Please upload the email below and the attached revised drawings and documents onto Ocella for **BN/30/20/DOC** regarding Angels Nursery, Yapton Road, Barnham.

Please find attached the further consultation response from **ADC Drainage Engineers** to discharge of condition application **BN/30/20/DOC** for Angels Nursery, Barnham.

Please see our further comments regarding surface water drainage relating to BN/28/20/DOC. 16/06/20 review comments are shown in *red italics*, items that are now closed are struck through.

Comments on surface water drainage (these comments also relate to BN/28/20/DOC);

TYPICAL PRECAST CONCRETE
CATCHPIIT

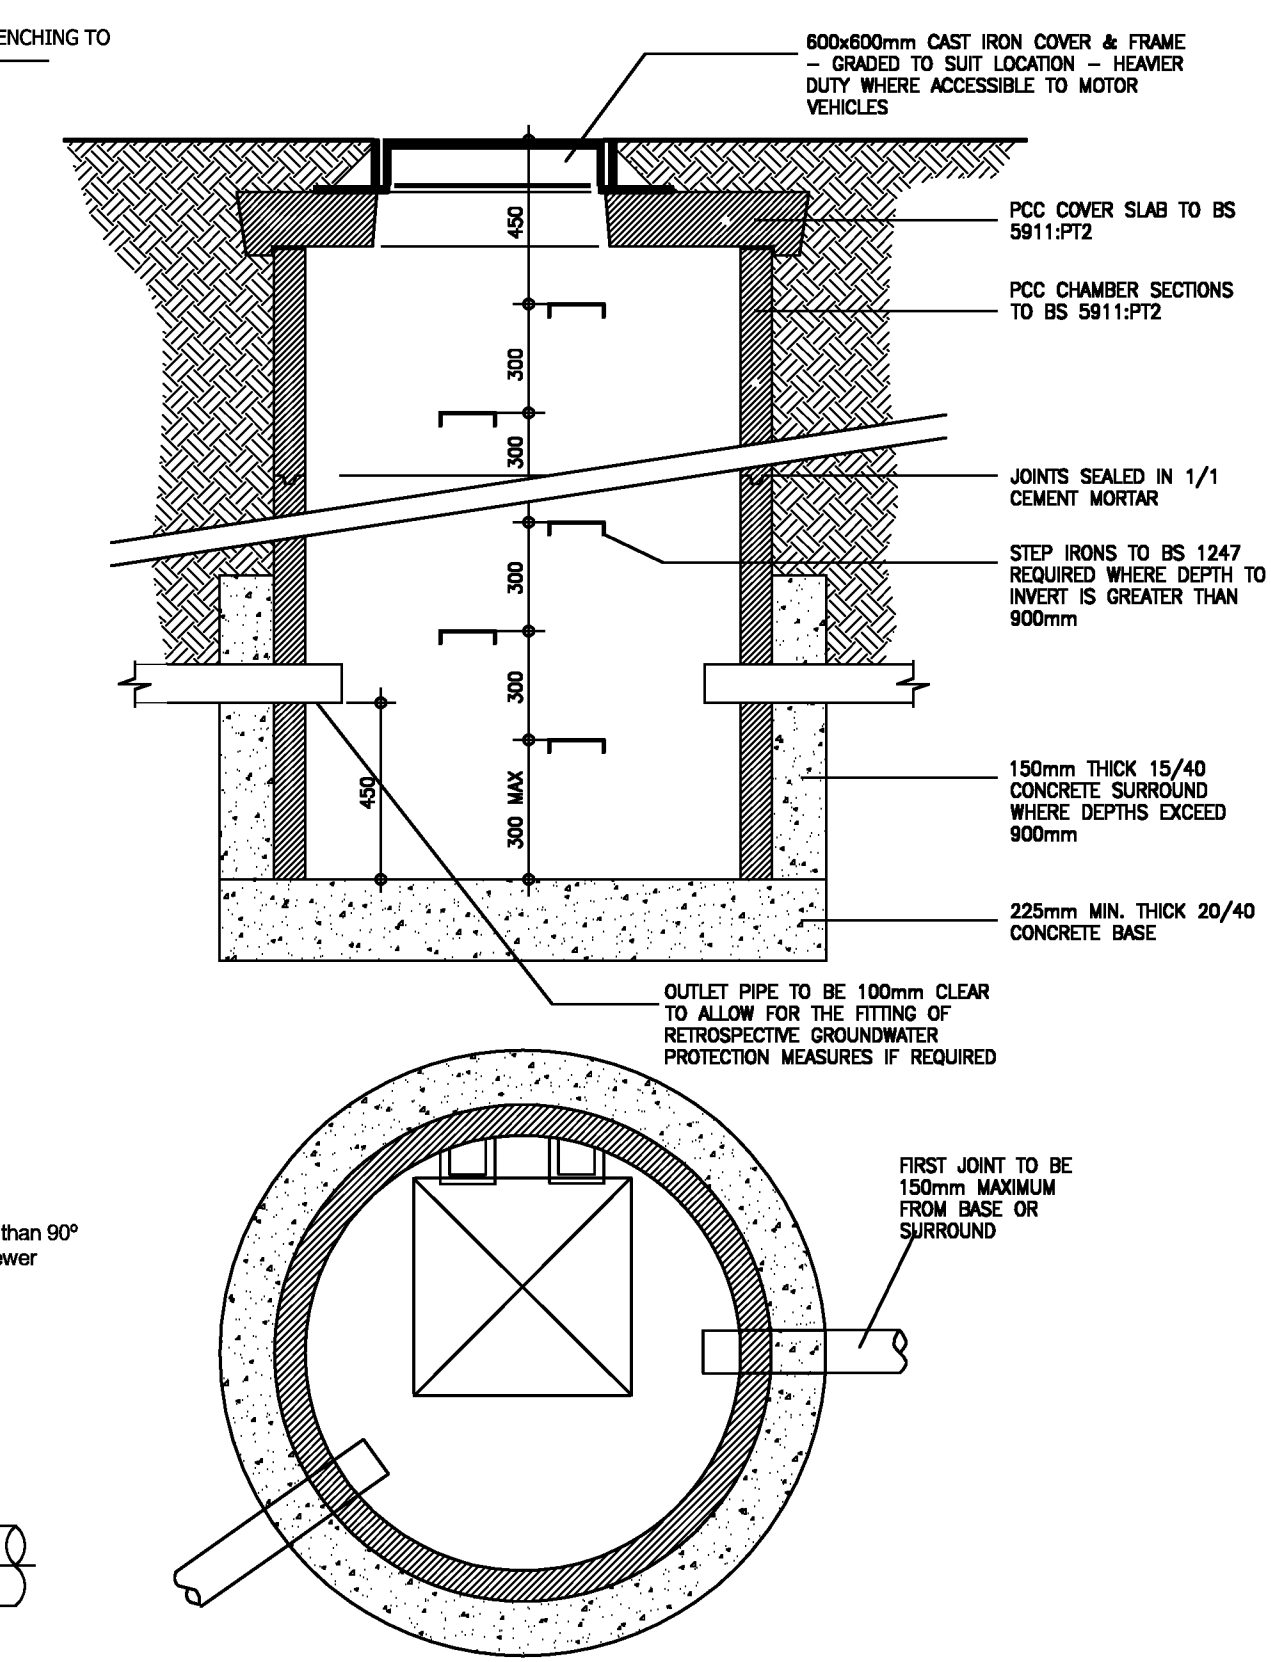
65. PCC ring catchpit detail – unsure if this type is being specified anywhere? If, so detail where and include brickwork under manhole cover/frame and extend concrete surround up to top of cover slab. Specify ring diameter. *Unclear as to where specified, include MH schedule.*

ADOPTED OUTFALL HEADWALL
SCALE 1:25

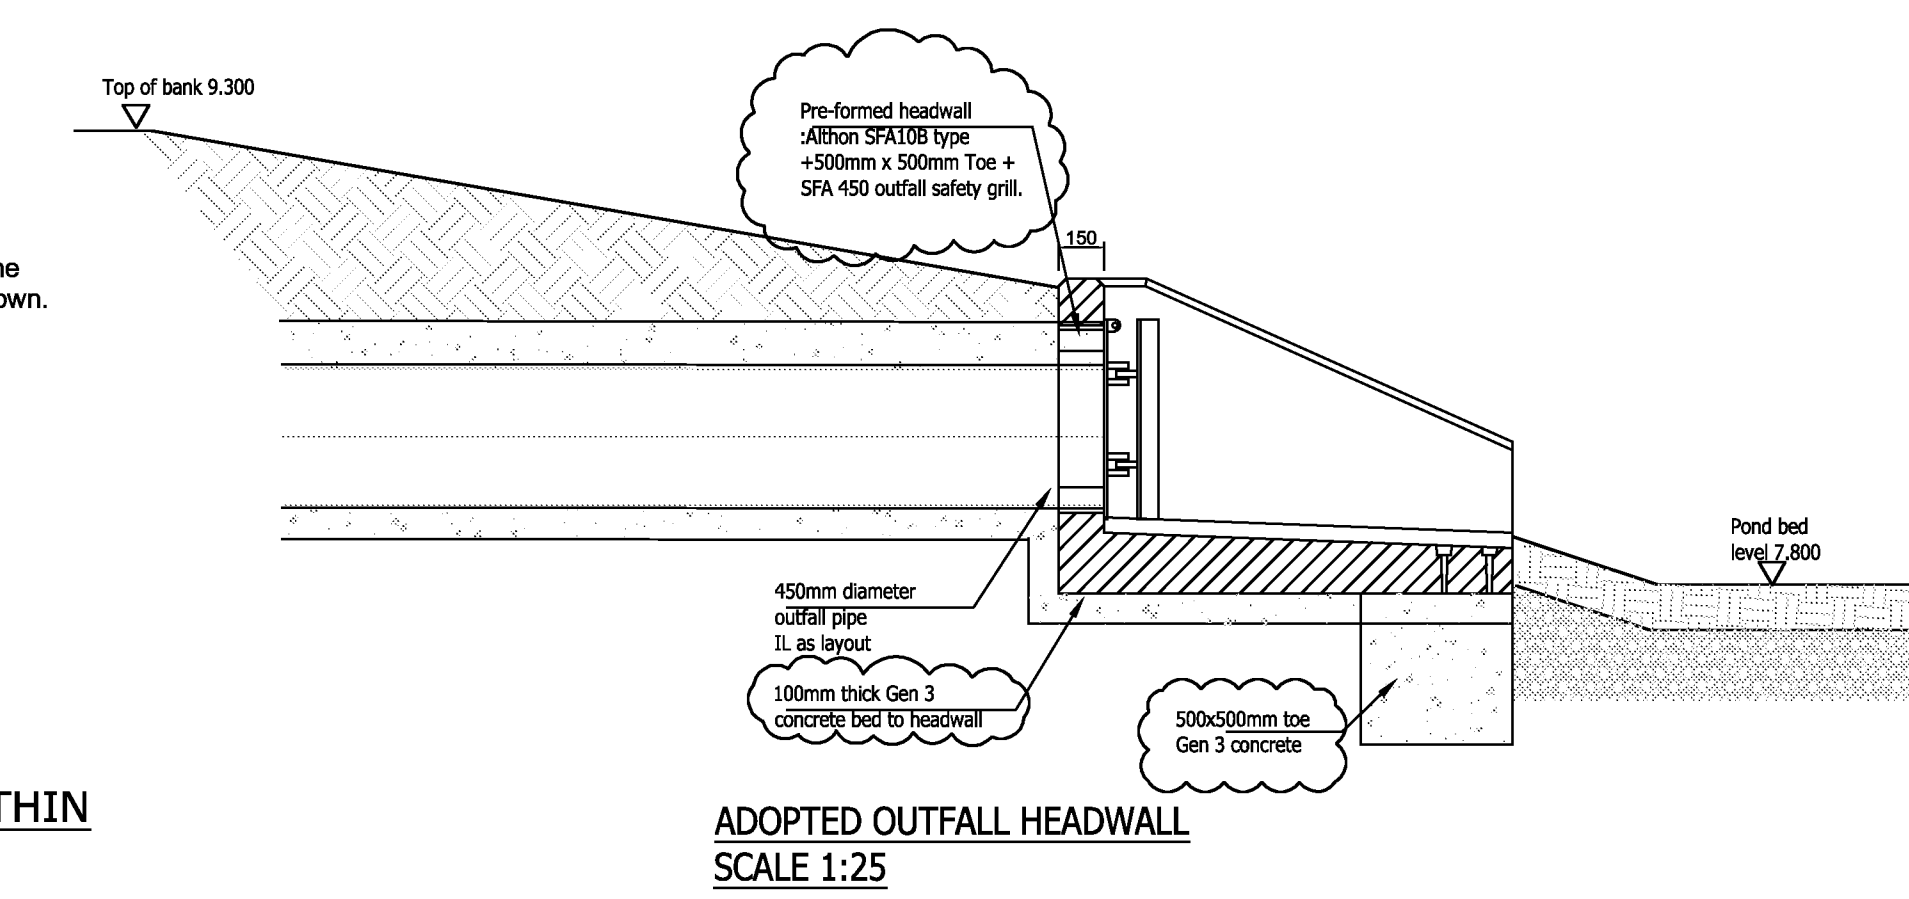
66. ~~Provide catch pit detail for all manholes immediately upstream of permeable paving connections.~~ *Okay.*
67. Adoptable outfall headwall detail – remove flat grille and specify cranked including bar spacings, etc. Incorporate Athlon detailed drawing within this drawing. Pond bed level shown as 7.800 but 7.900 on plans. *Please address points.*

DRAWING No. 19812-GS-Z1-XX-DR-C-5102

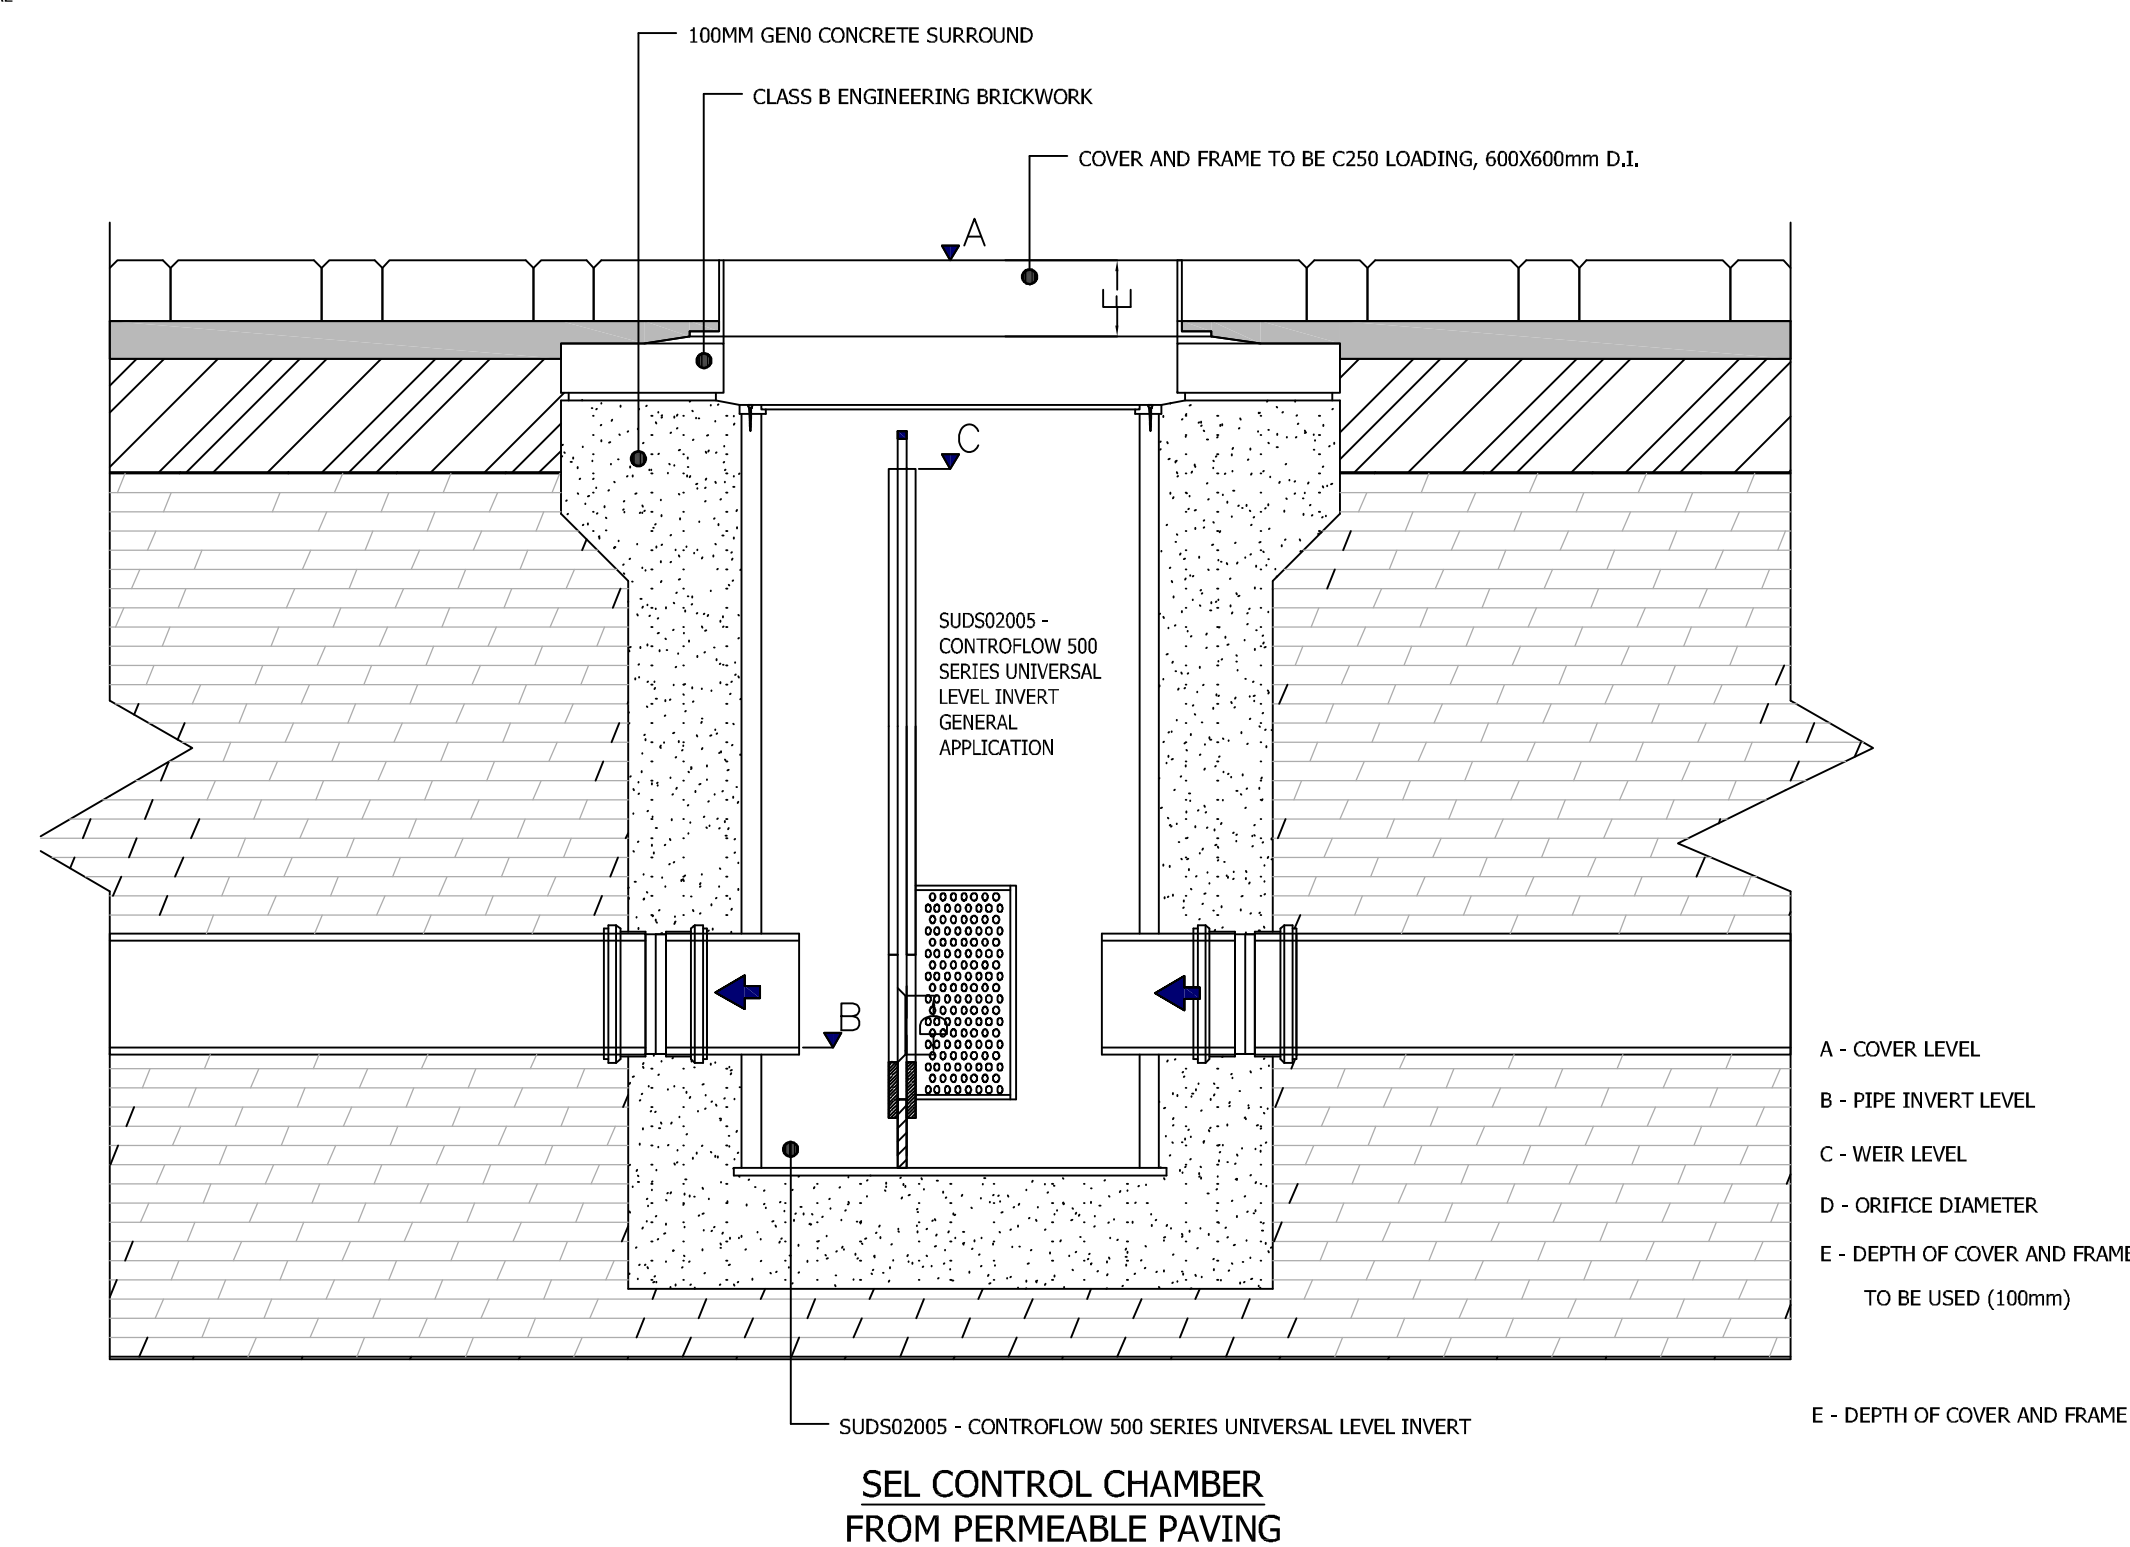
64. Hydrobrake chamber detail – rings to be surrounded in 150mm thick concrete and to be extended down to the bottom of its base. All to be ST4 concrete. Add benching construction notes and include hydro international details referred to. *Note is not clear that surround extends to bottom of base, benching note missing, hydro international details not included.*

DISTRIBUTION/COLLECTOR TANK DETAIL WITHIN TANKED PERMEABLE PAVING (MARKED DT ON LAYOUT)

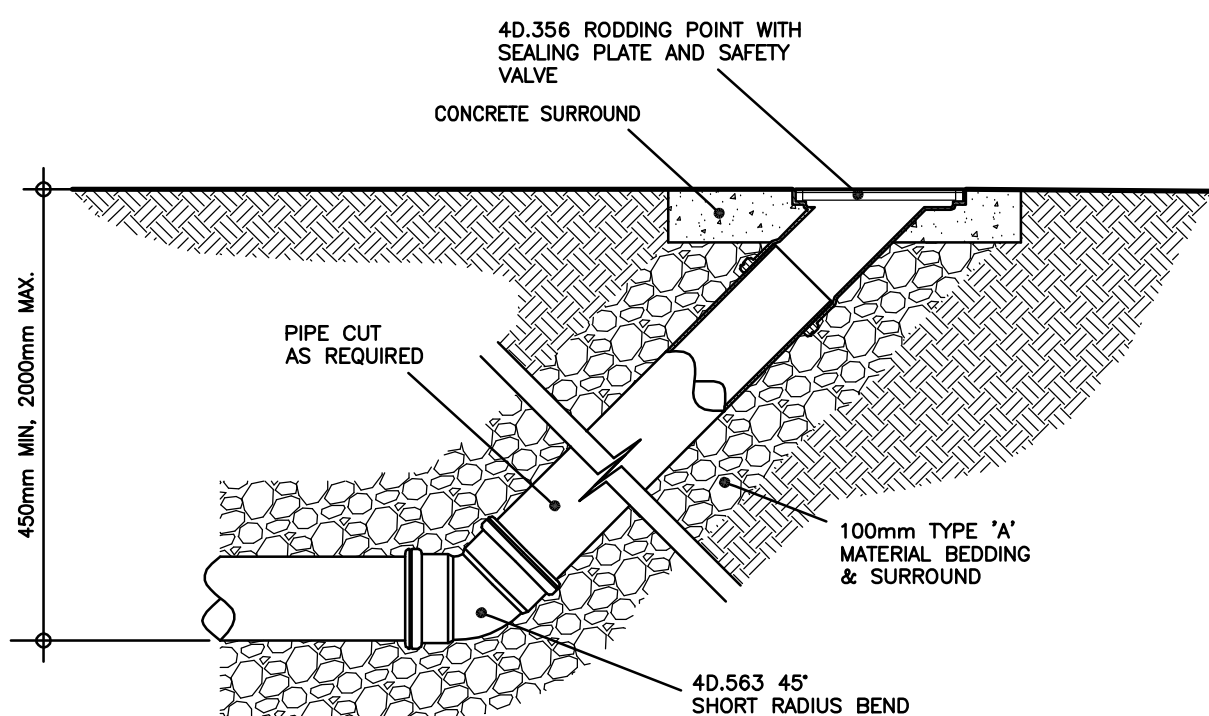
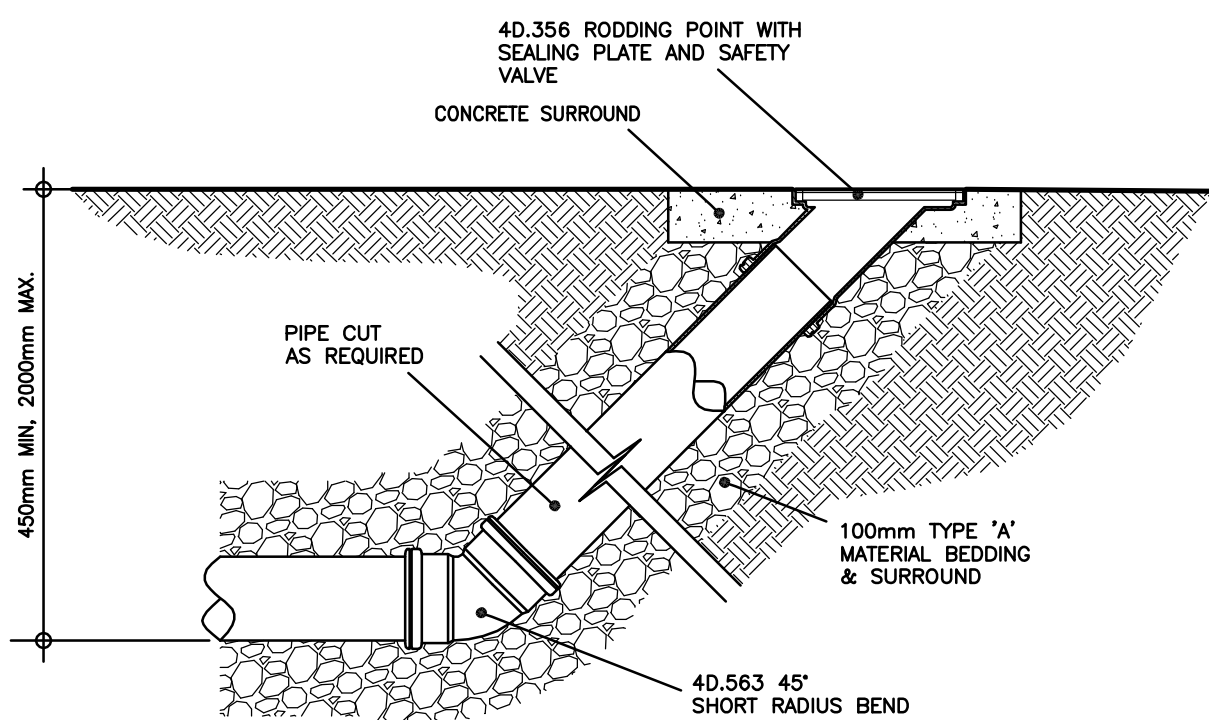
73. Provide construction detail distribution tanks on permeable paving outlets. *Please make it clear that invert level of outlet tanks is at formation level.*
